WEST SUSSEX COUNTY COUNCIL CONSULTATION

TO:	Arun District Council FAO: Claire Potts
FROM:	Highways, WSCC
DATE:	12/9/2018
LOCATION:	Land south of New Road (A259) and East of Brook Lane, Angmering
SUBJECT:	A/23/15/OUT Hybrid application - Full Planning Permission for a retail unit (Class A1) comprising 1,487sqm (1022sqm ground floor and 465sqm mezzanine) with associated access, car parking, servicing, landscaping & associated works. Outline Planning Permission for a public house (Class A4) comprising 581sqm at ground floor level - This is a Departure from the Development Plan Amendment plan. Amendment received. Amendment received on 22.08.2018.
DATE OF SITE VISIT:	
RECOMMENDATION:	☐ Advice ☐ Objection ☐ Modification ☒ No Objection ☐ More Information ☐ Refusal
S106 CONTRIBUTION TOTAL:	N/A

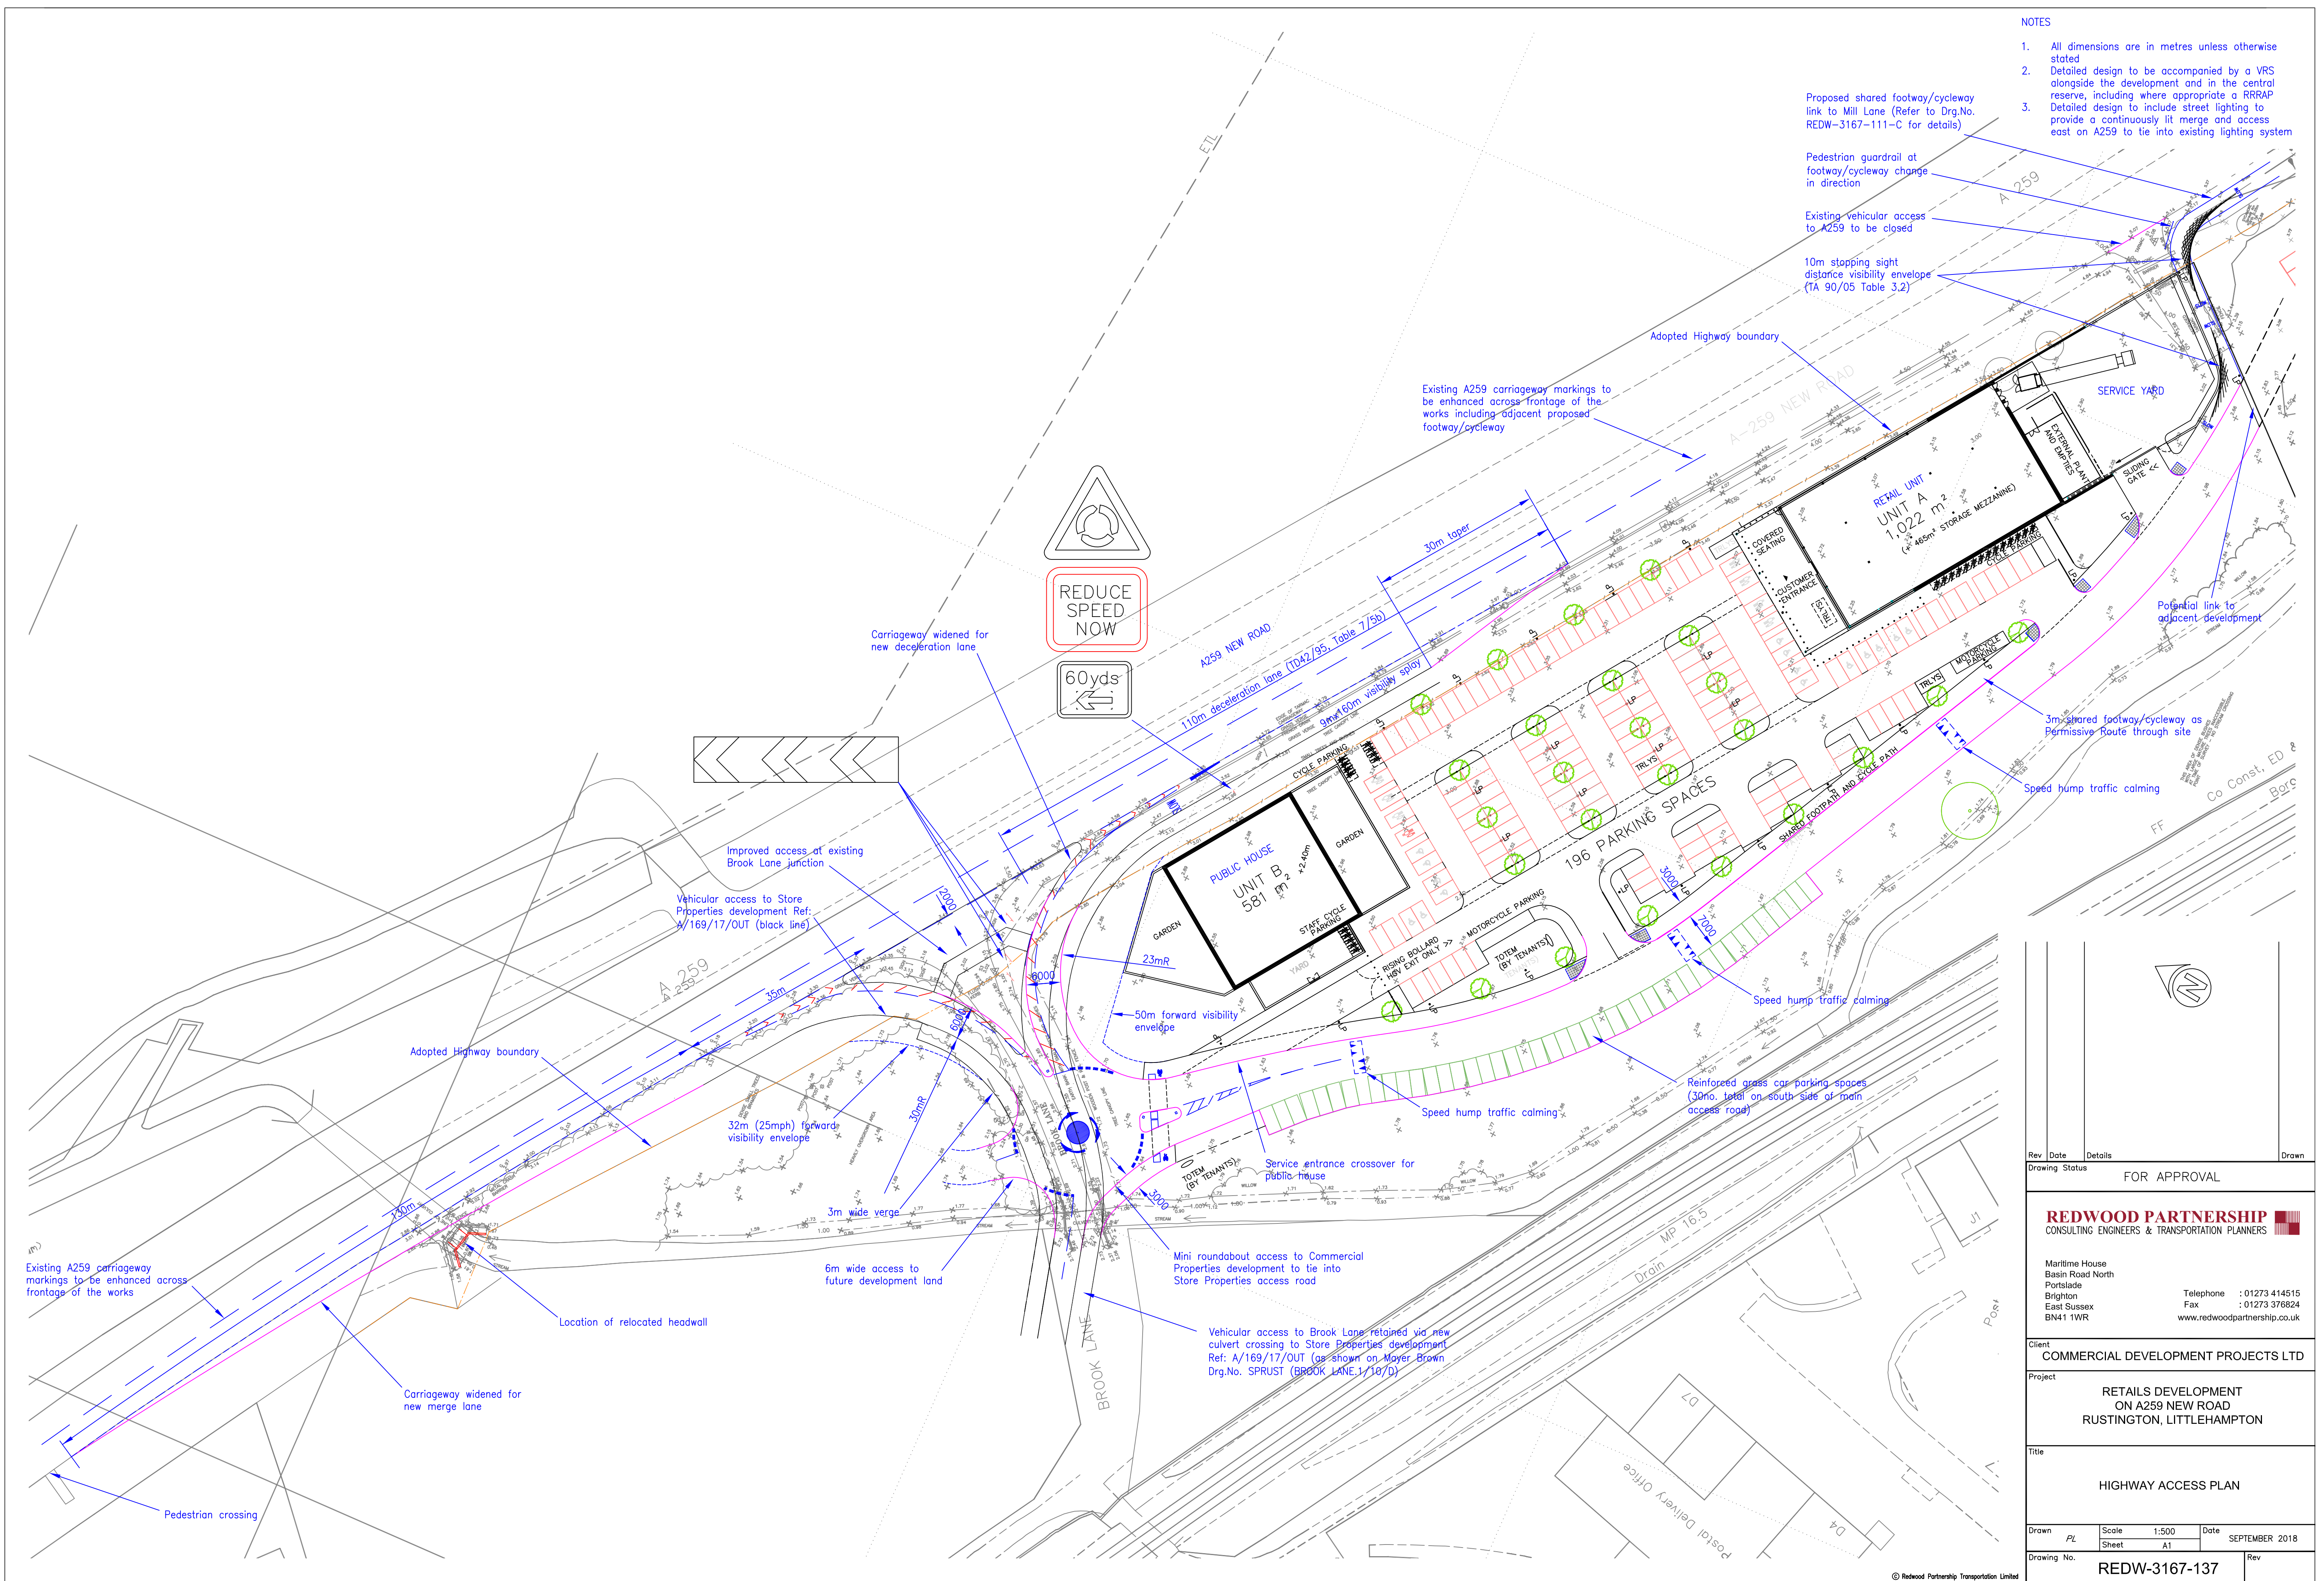
WSCC as Highway Authority have been reconsulted on revised plans submitted on 22nd August 2018. The revised plans detail that an additional arm off the min-roundabout could be provided to facilitate access to the adjacent site to the west, which benefits from outline planning consent.

The Highway Authority previously raised concerns that the applicant had failed to demonstrate that this development did not preclude committed development on the adjacent site from coming forward. The revised drawing now demonstrates that there is the potential for an access to be provided to facilitate access to the site to the west. This addresses the previous Highway Authority concerns.

- The need to produce and submit a Construction Management Plan
- That the car, cycle and motorcycle parking and internal access road, turning areas and footways and cycleways are constructed prior to first occupation of the units hereby approved
- The need to deliver the site access from the A259 in accordance with the approved drawing
